from
**Southern
Water**

Our ref
PLAN-036812

Proposal: Development of 2 No 2-bed & 2 No 3-bed detached dwellings & associated works. This site is in CIL Zone 3 and is CIL Liable as new dwellings.

Site: CM/53/20/PL: - Land at Wren Cottage, Horsemere Green Lane, Climping, BN17 5QZ.

SITE PLAN
SCALE 1:500 @ a3

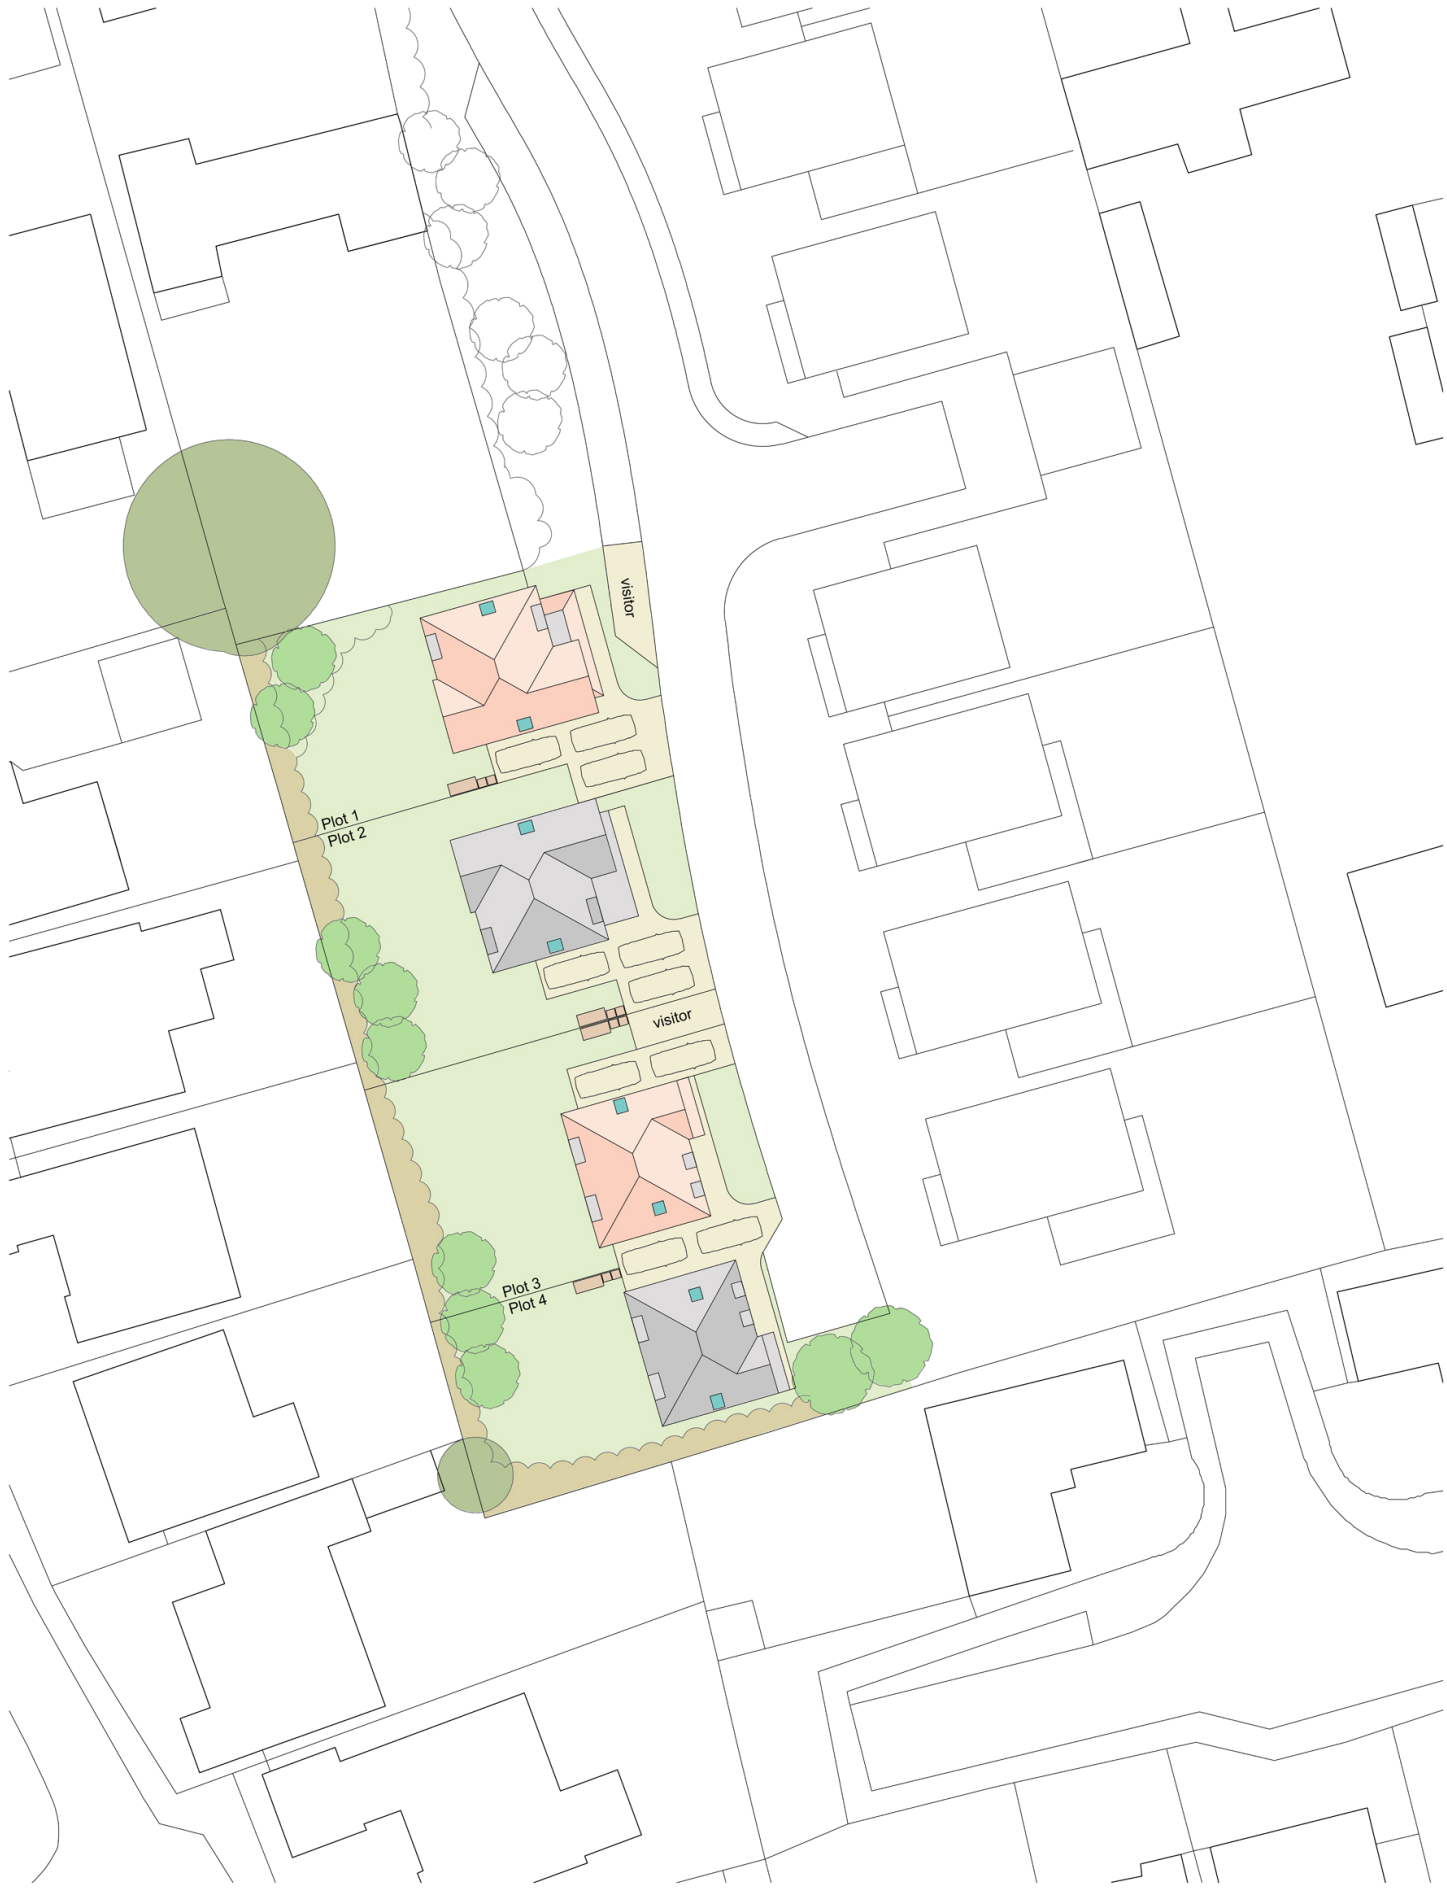
Please see the attached extract from Southern Water records showing the approximate position of our existing foul sewer within the development site. The exact position of the public asset must be determined on site by the applicant in consultation with Southern Water before the layout of the proposed development is finalised.

- The 150 mm diameter gravity foul sewer requires a clearance of 3 metres on either side of the gravity sewer to protect it from construction works and to allow for future maintenance access.
- No development or tree planting should be carried out within 3 metres of the external edge of the public gravity sewer without consent from Southern Water.
- No soakaways, swales, ponds, watercourses or any other surface water retaining or conveying features should be located within 5 metres of public or adoptable sewer.
- All existing infrastructure should be protected during the course of construction works.
